# City of Albuquerque

RE: ALBUQUERQUE WEST, UNIT 1, TRACT A, PROJECT NO. 3791.90

**Re: Fountain Hills Drainage Management Plan  
Engineer's Stamp dated 6-4-07, (C12/D3B)**

Prior to Final Plat, Work Order or Building Permit approval, please address the following comments.

FOUNTAIN HILLS
GRADING & DRAINAGE MANAGEMENT PLAN
PROPOSED BASIN MAP
ALBUQUERQUE, NEW MEXICO
JUNE, 2007

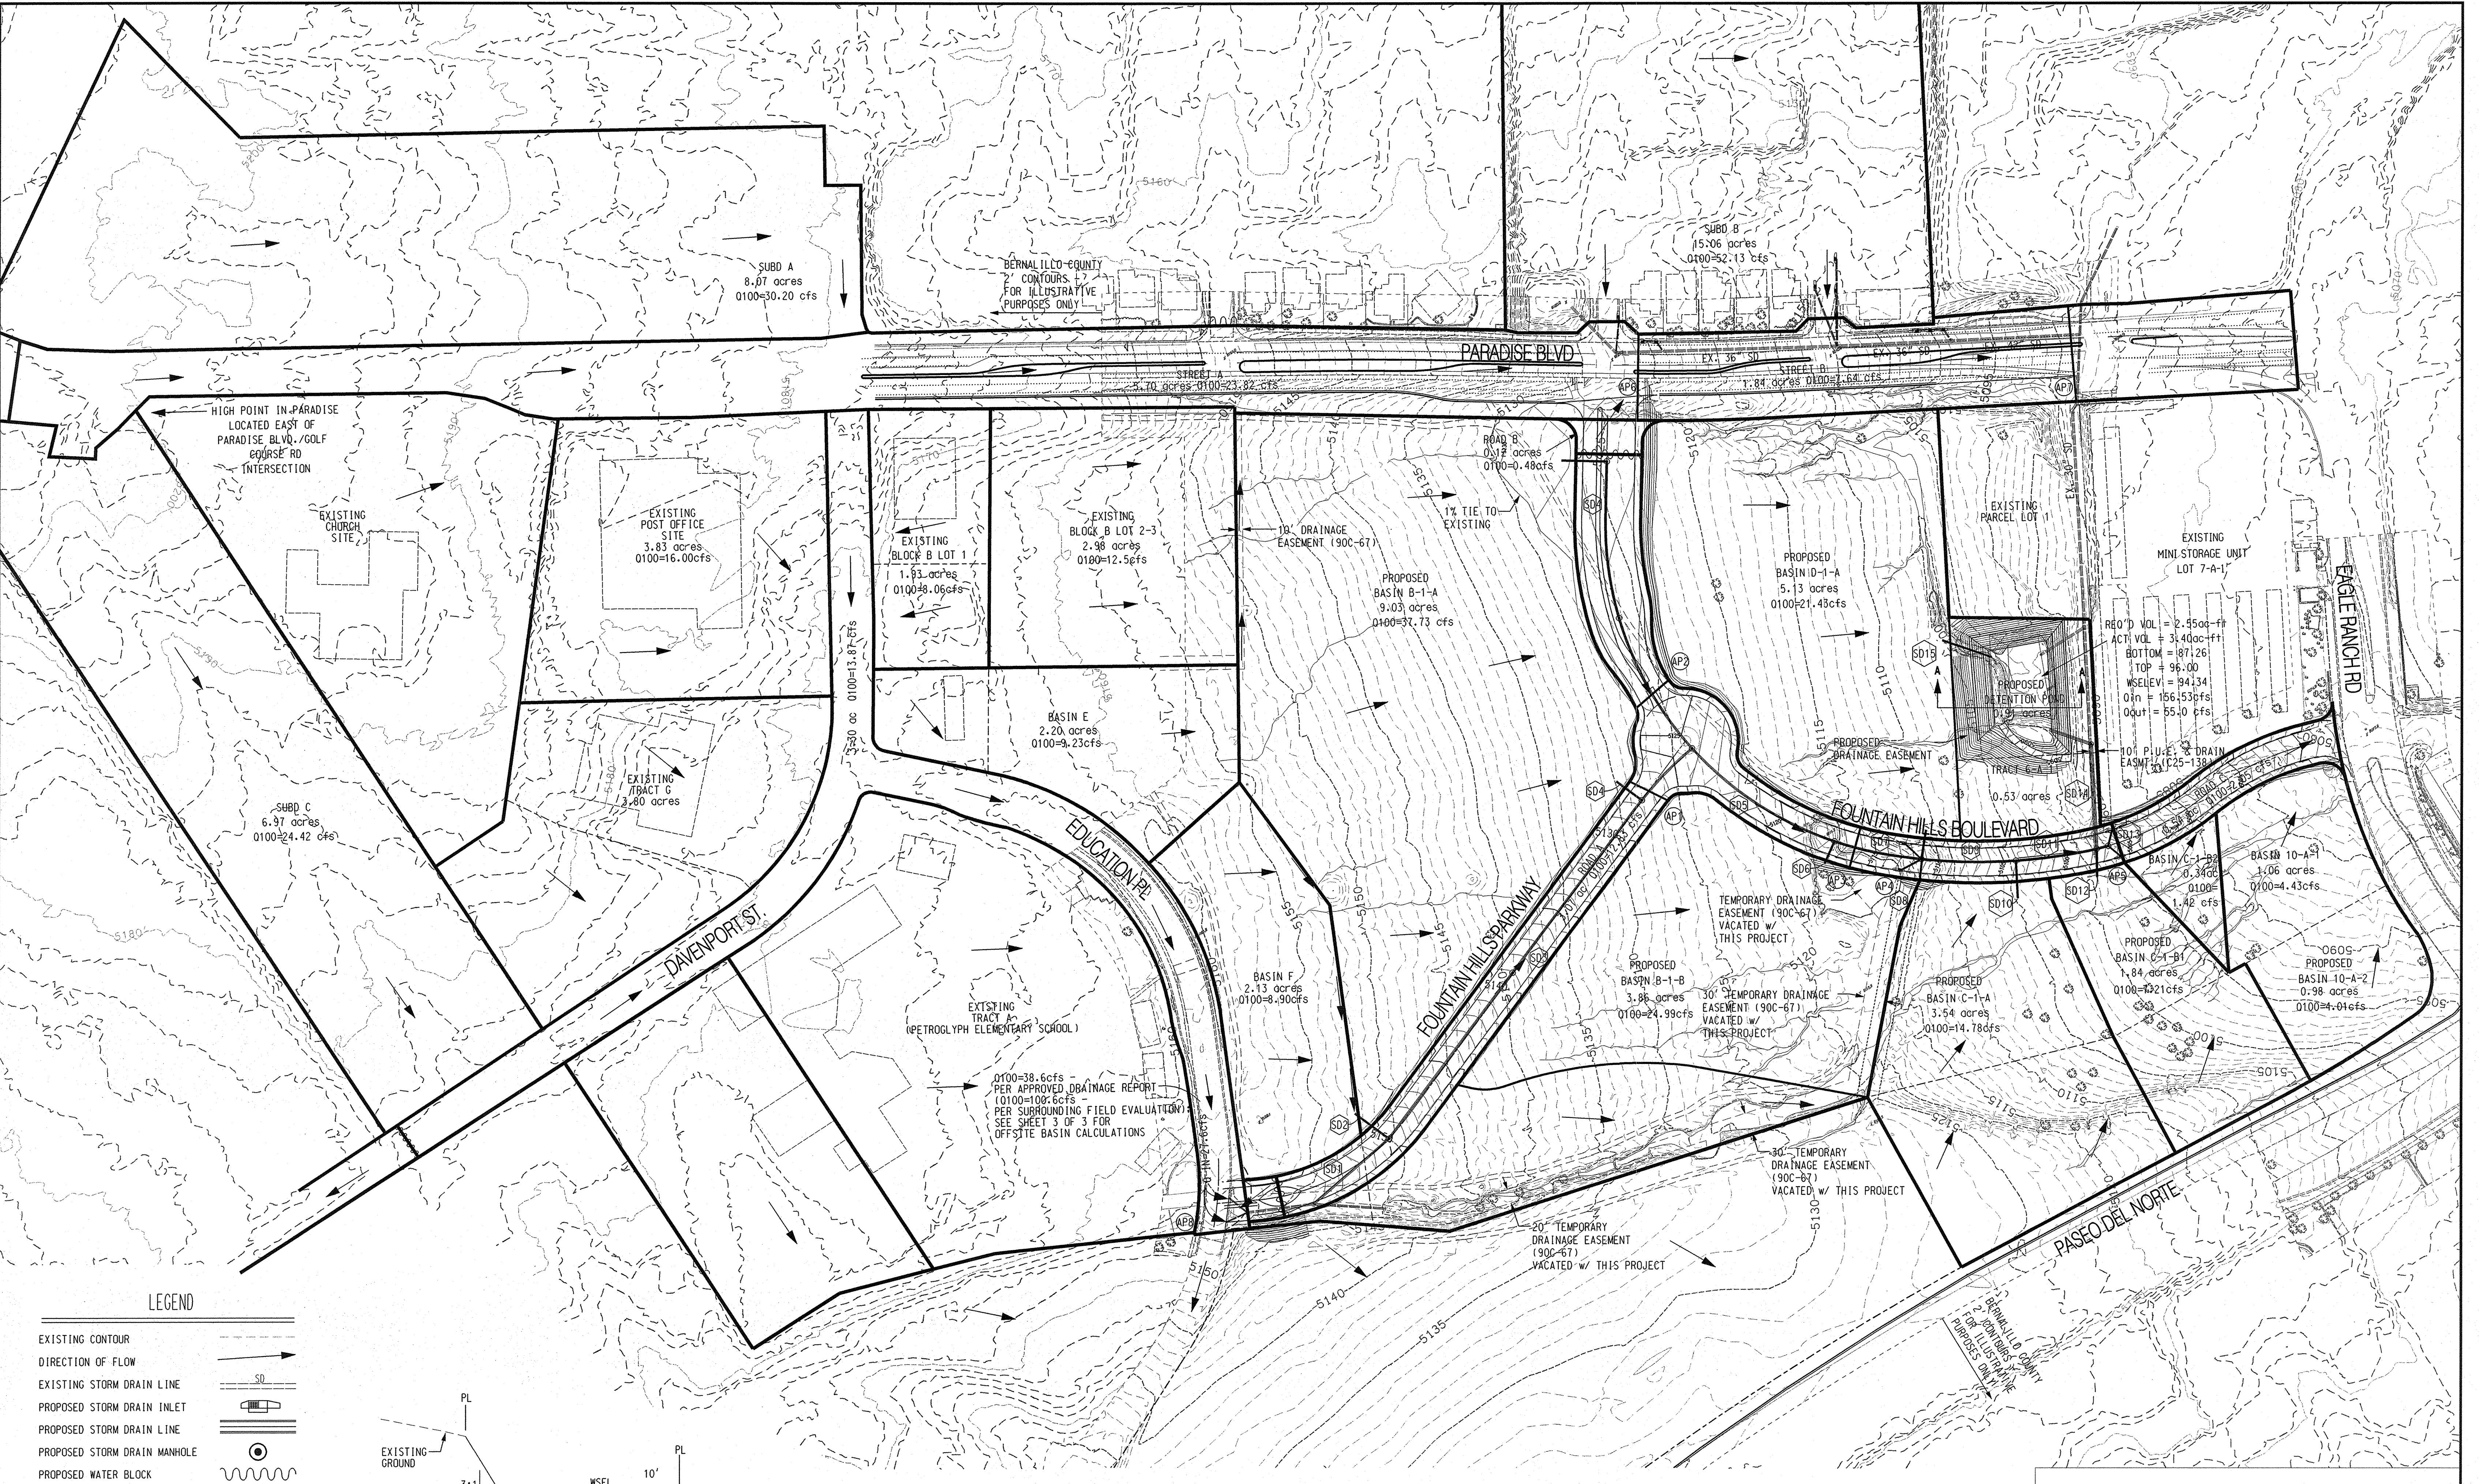
- The developed portion of Basin E drains to Education Place and the rest will drain through Basin F to SD2. Please update sheets 2 and 3 accordingly.
- The church site on Paradise does not drain to the post office. There is a pond on the south corner that retains a portion of the property.

- Since you will be modifying the inlets on Education Place with the construction of Fountain Hills Parkway, please provide enough inlet capacity to get as much as possible the 38.6 cfs allowed in the Fountain Hills storm drain.
